13 July 2021

William Hodgkinson
Team Leader
Industry Assessments
Department Planning, Industry & Environment

RE: Mayfield West Waste Facility-Mod-1 (SSD-7698-Mod-1)
Request for additional information

Figure 1. SSD 7698 Proposed Modification to the Development Layout Plan

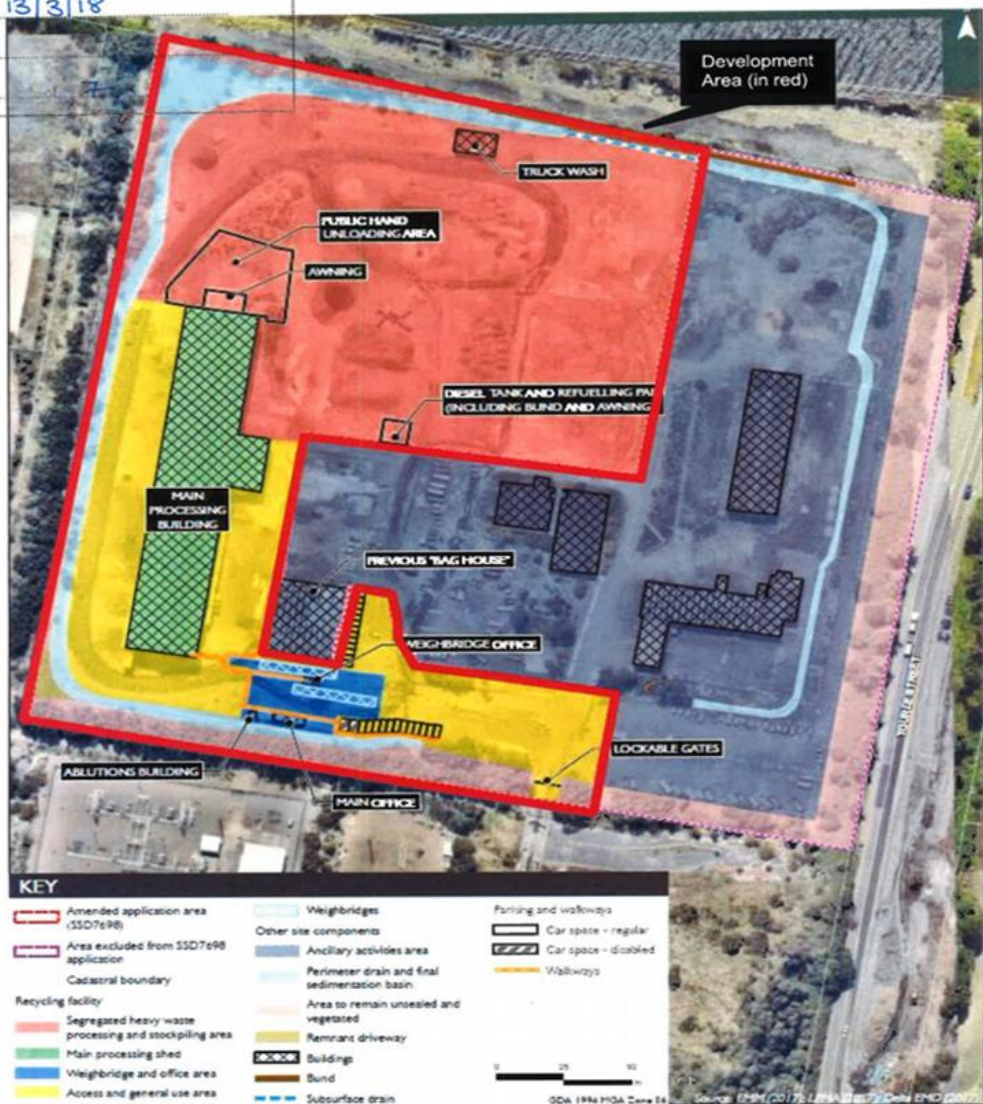
- Provide an updated Development Layout Plan (Appendix A of SSD 7698)

Benedict response: See revised Development Layout Plan attached to this response.

Figure 4. Layout plan for proposed hand unload shed and apron area

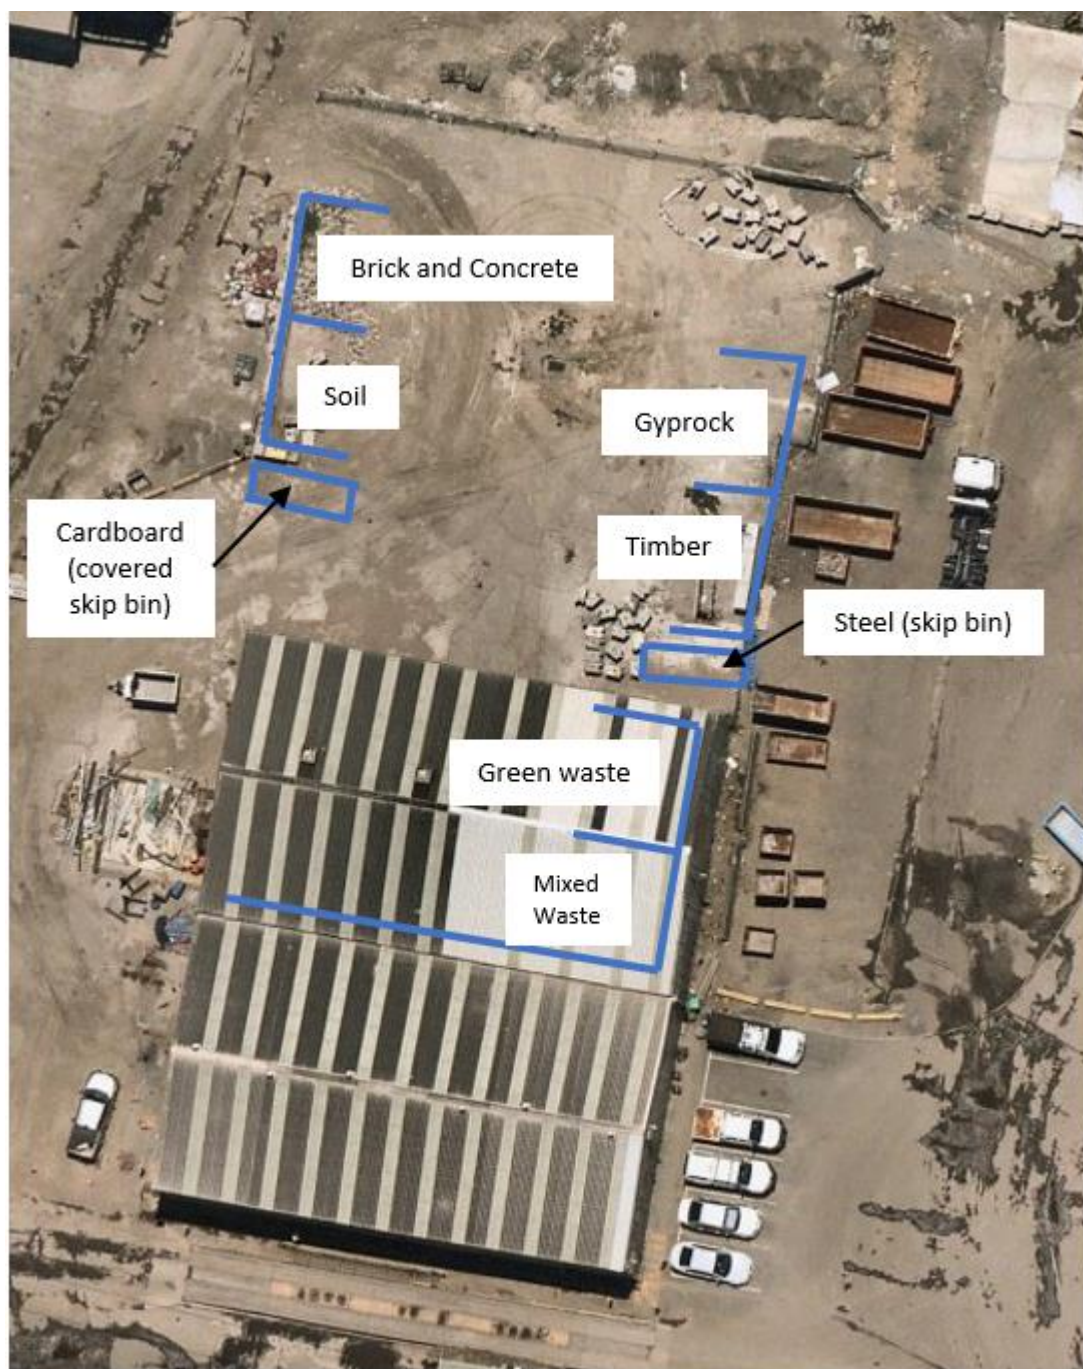
- *Show where hand unloading would take place in Figure 5 Conceptual layout plan for proposed hand unload shed and apron area of the Modification Report.*

- Clarify where light waste will be stored and provide the storage capacity for the bins in the apron area for cardboard, metals and nonferrous metals.

Benedict response: See diagram.

Benedict response: Light waste will be stored in the shed Mixed Waste bay coloured grey on the Figure 5 Conceptual layout plan for proposed hand unload shed and apron area'. The sizing for the bins will be:

- Cardboard: 10 – 15m³ bin
- Metals (ferrous): 25 – 30m³ bin
- Non-ferrous: 25 – 30m³ bin
